Re: Project #PR-2019-002496 for Southeast Corner of Alameda Blvd. NE & Barstow Street NE

Vineyard Estates Neighborhood Association is aware of the upcoming [re]hearing for an application by Consensus Planning for a site plan on behalf of Philip Lindborg and the Mantoni

Family Trust for development of 93 apartments on the southeast corner of Barstow Street NE and Alameda Blvd. NE on August 14, 2019. It is our continued understanding that the property zoning is MX-L under the current IDO and this application is a permissive use of the property. Additionally, it

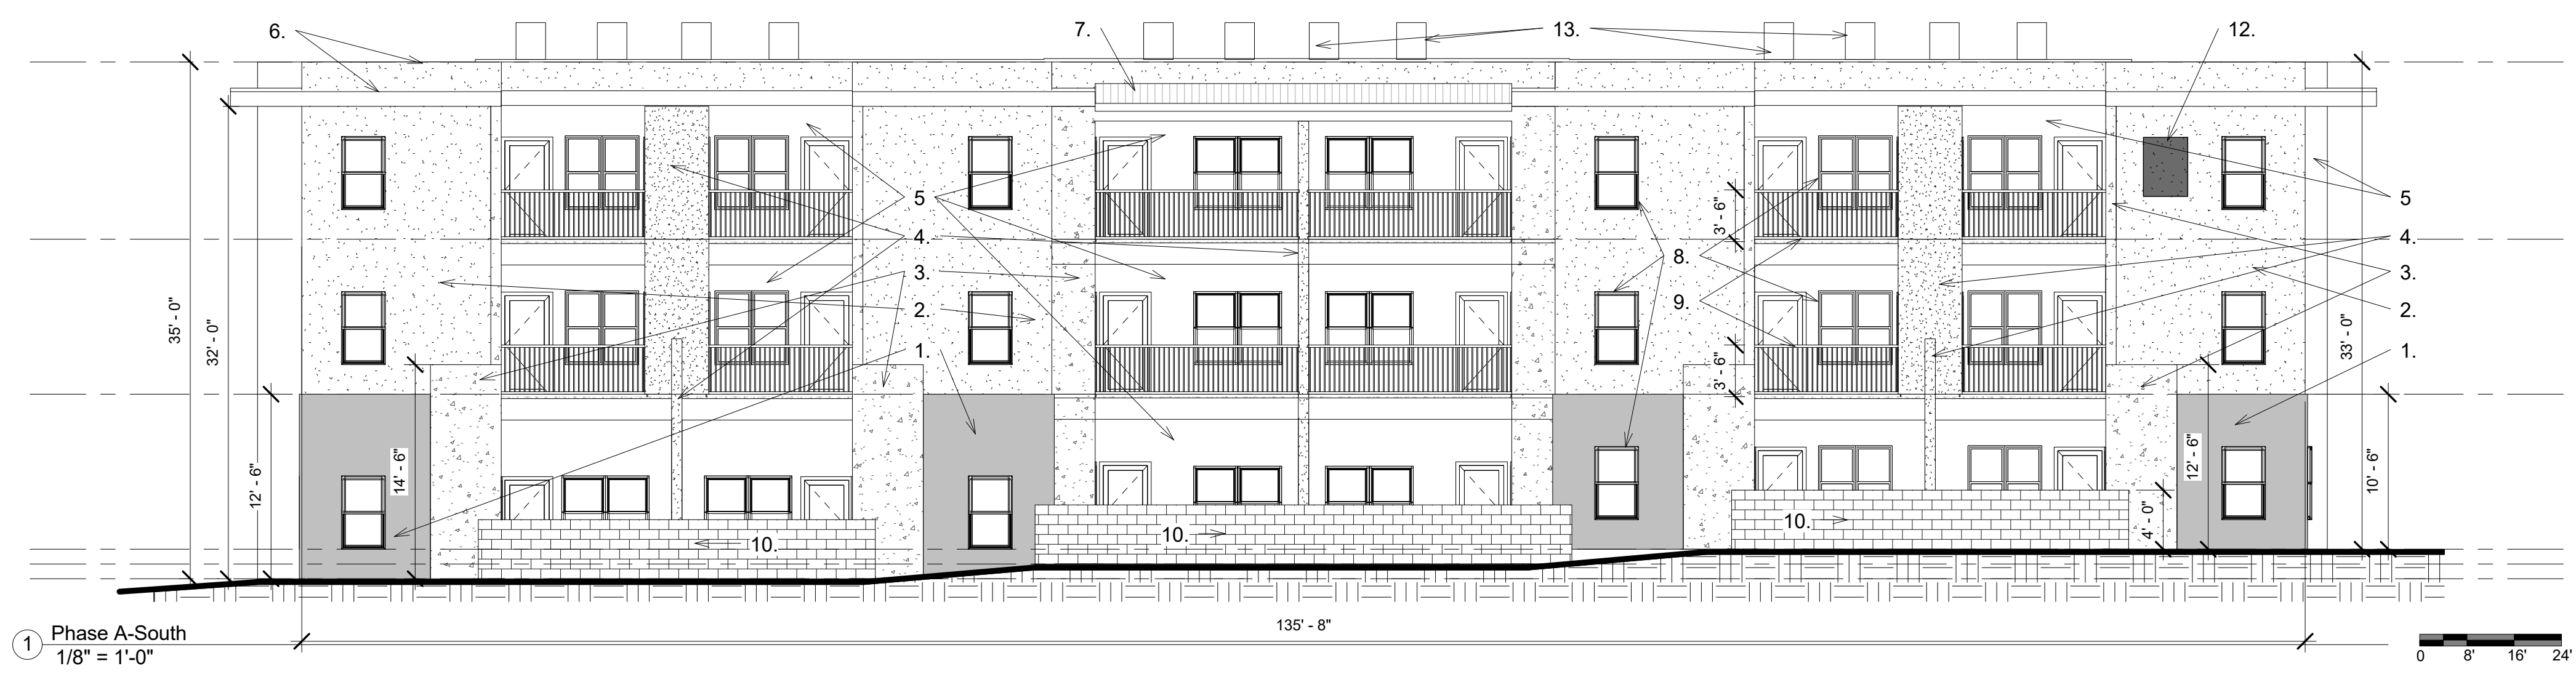
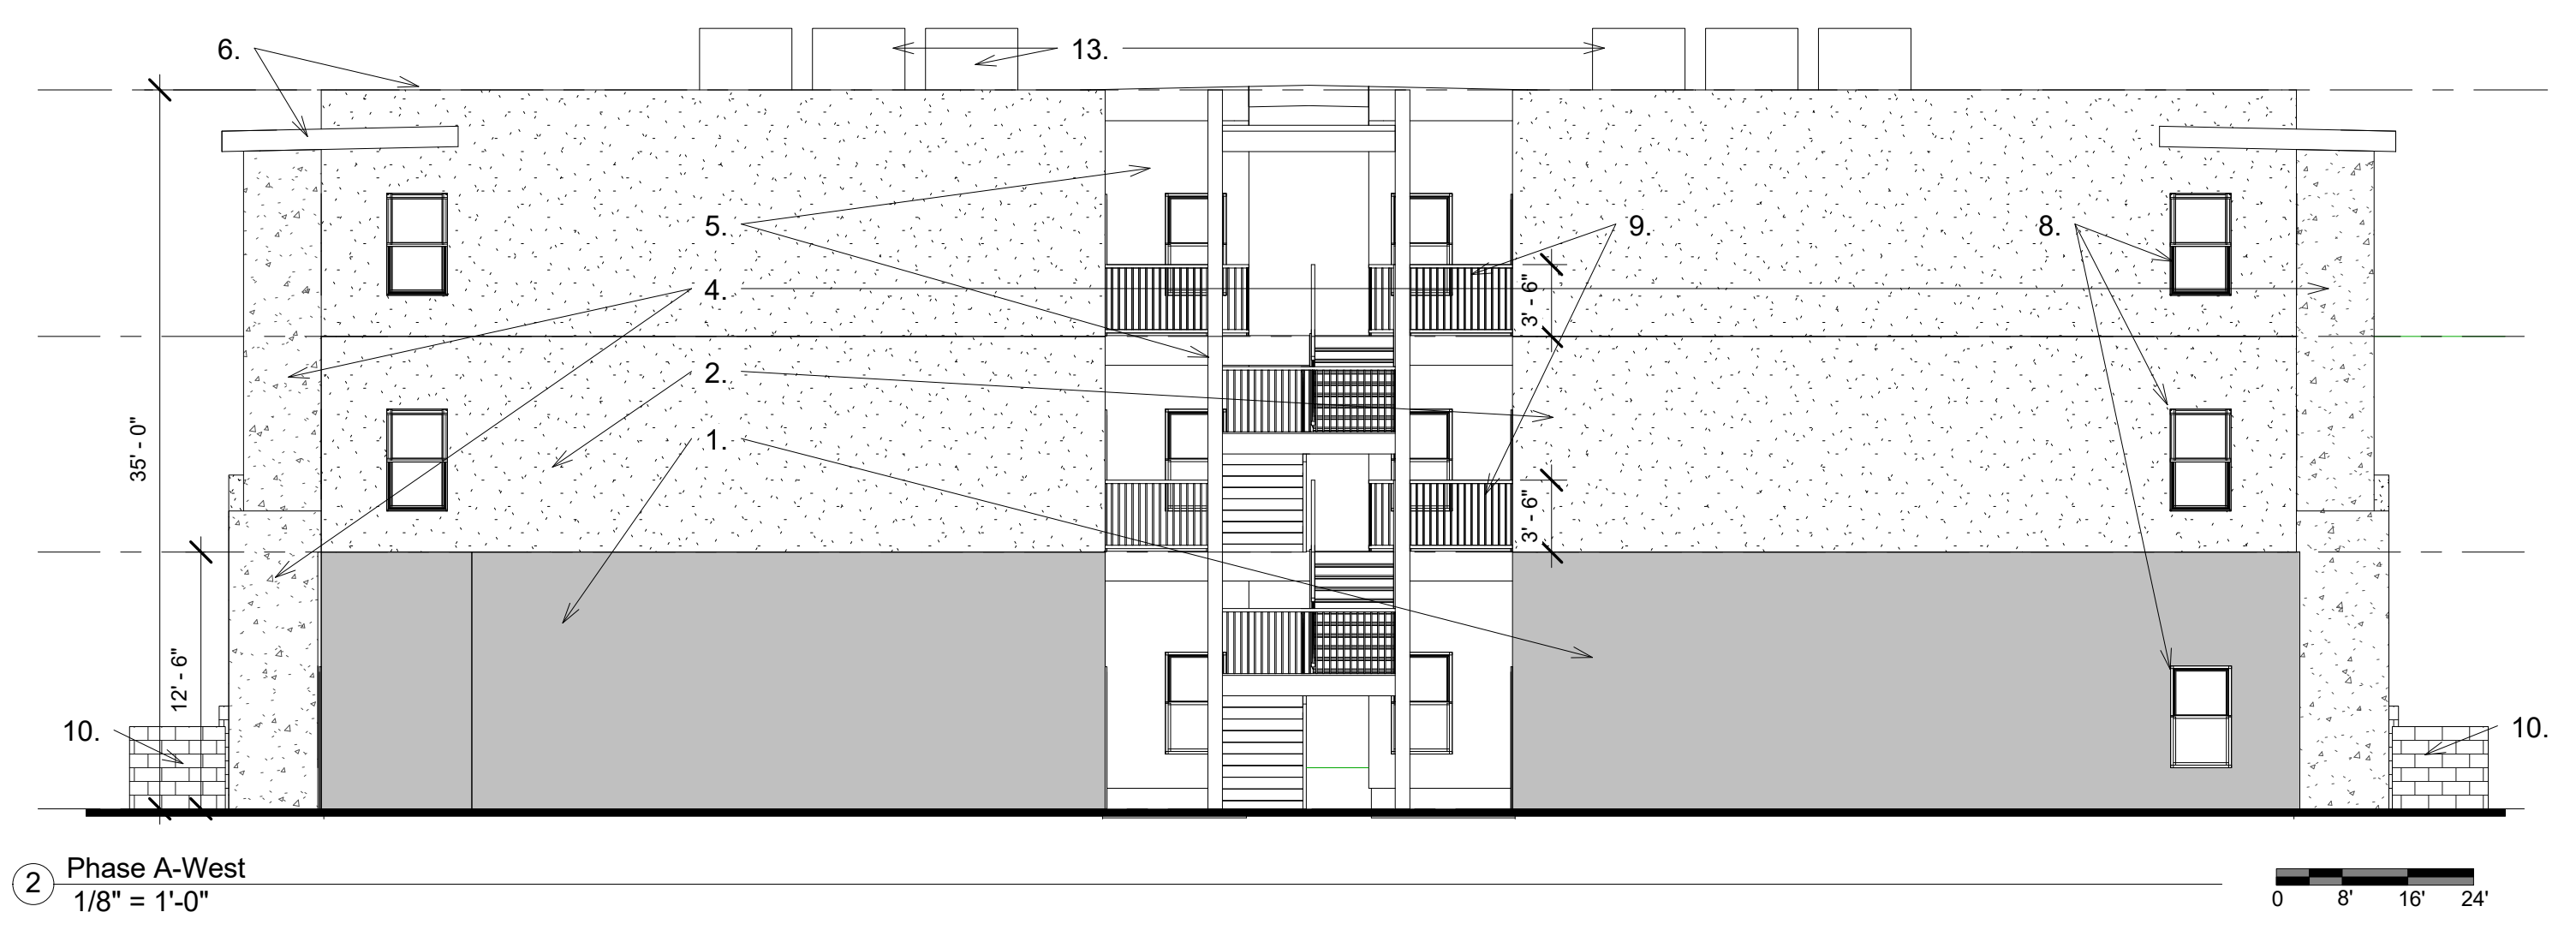
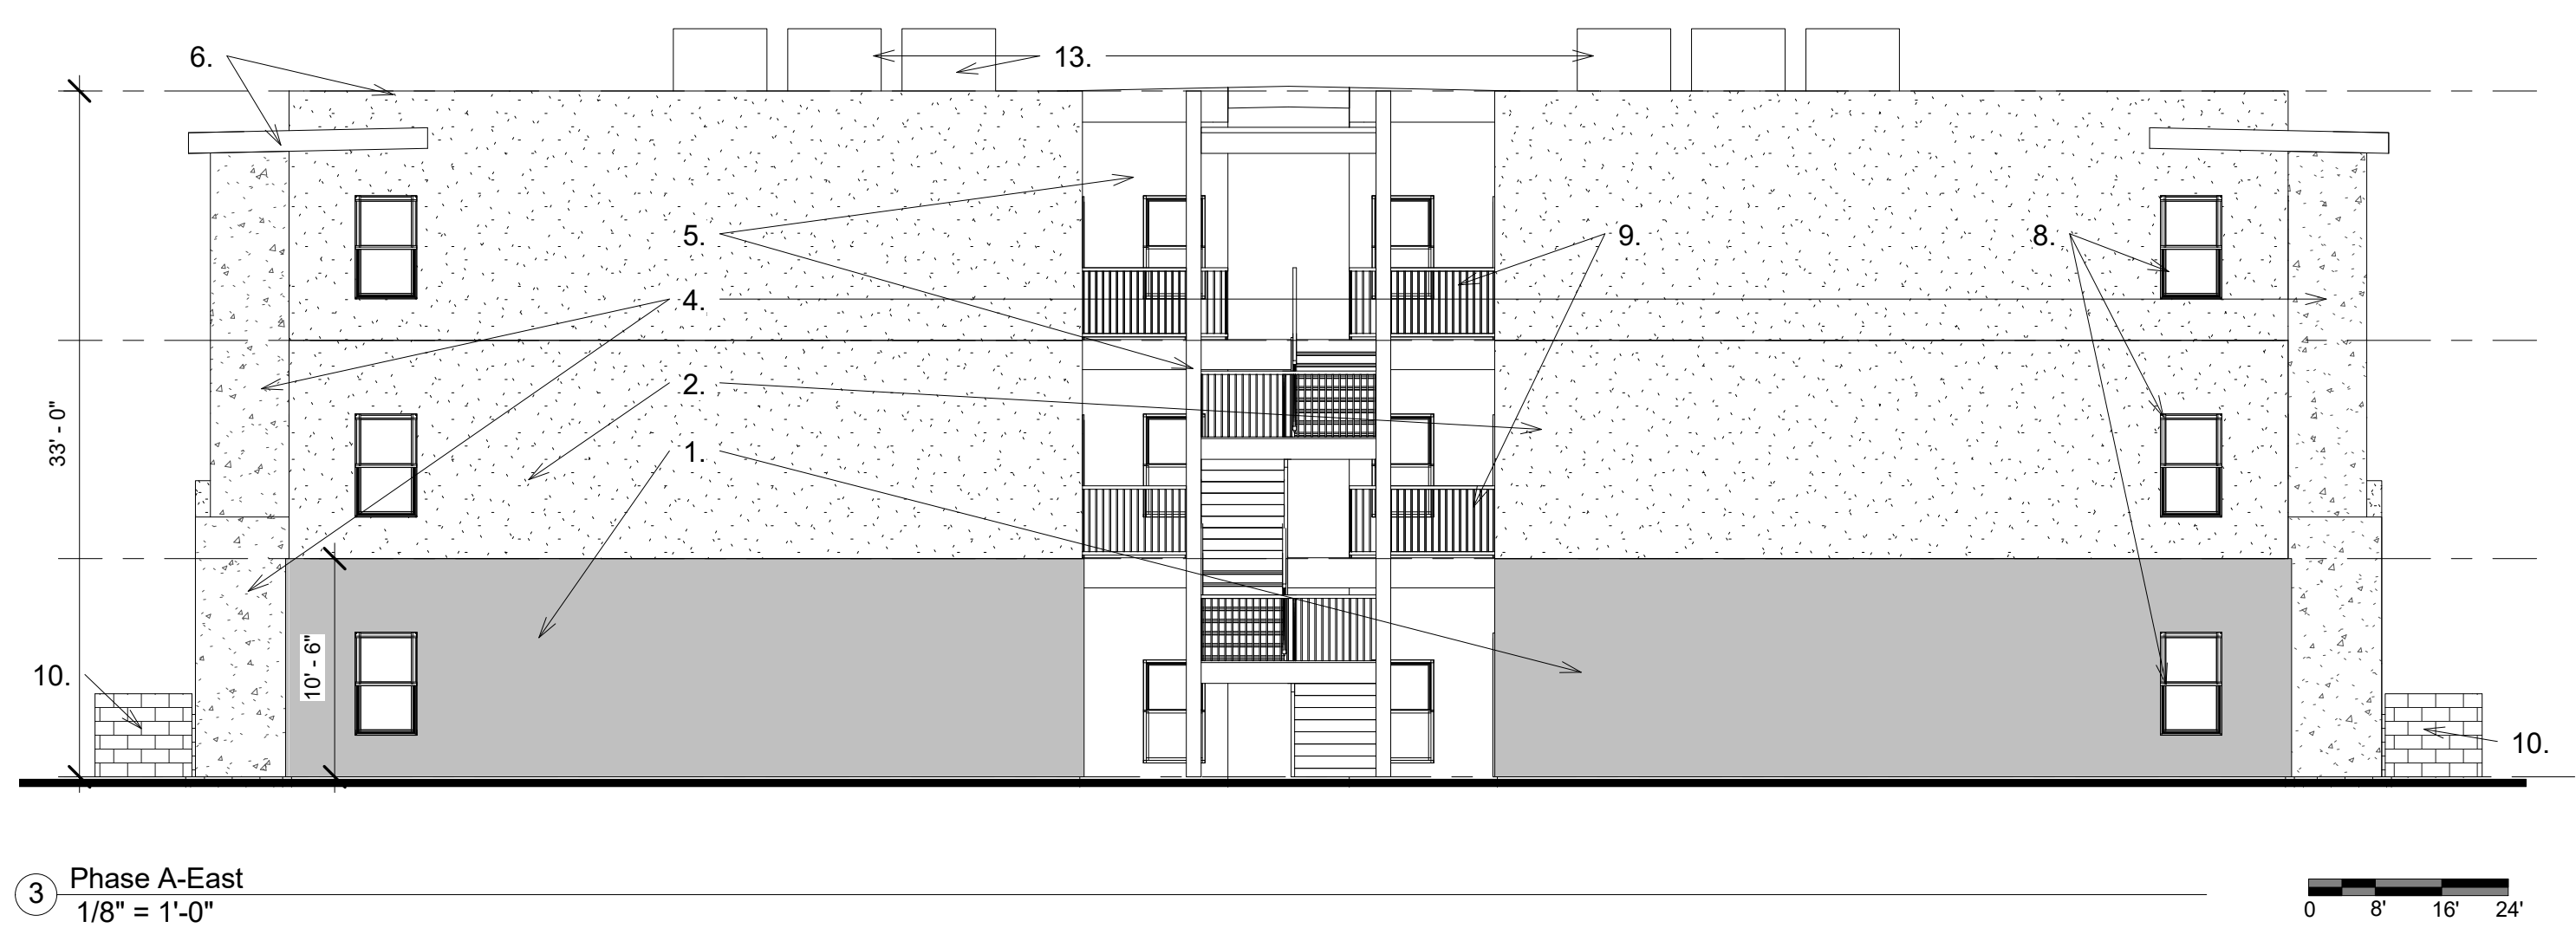
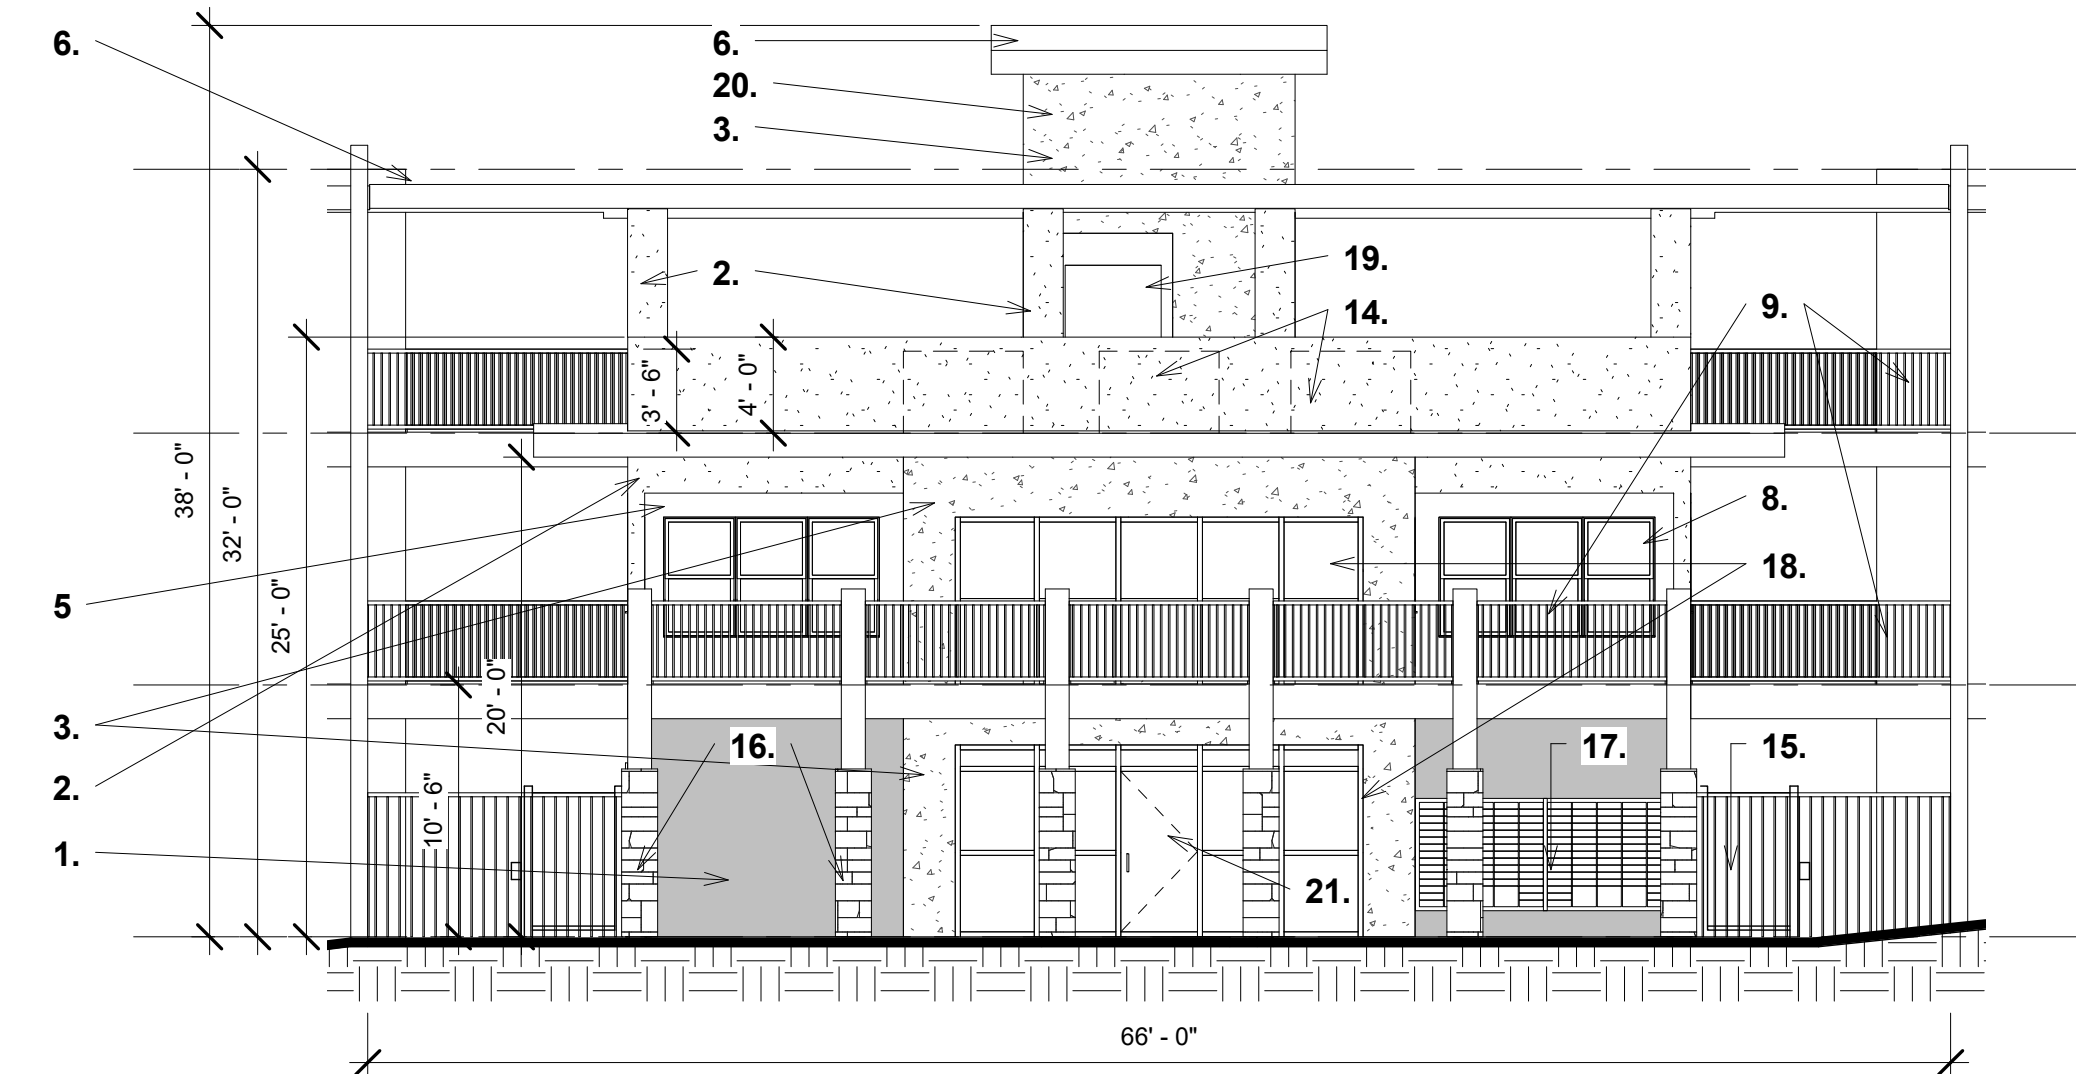
- 4) ***Urban Design Style:*** The design style of a 3-story, flat roof, brightly colored building (medium-grey, tan, red-orange, off-white, orange-yellow per Jeebs & Zuzu, Inc. June 2018

provided documents) does not blend in with the surrounding earth tone homes (many of which have covenants clarifying appropriate paint color choices of which most of these colors would not be allowed) and gabled roofs of Tierra Morena (south-affected neighborhood), Pico la Cueva Place (north-affected neighborhood), and Tierra Montana Place NE (west-affected neighborhood). Using an example of an Italian design in a southwest style neighborhood, again does not blend in or enhance surrounding home values. Use of black chain-link fencing as the security surround also does not fit with the tasteful design required by the surrounding neighborhoods' covenants of stuccoed walls or wrought-iron gates/fencing to contain yards and pools. Additionally, there appears to be an inadequate amount of landscaped "green/open space" relative to the size of the property and amount of black asphalt parking surrounding the buildings.
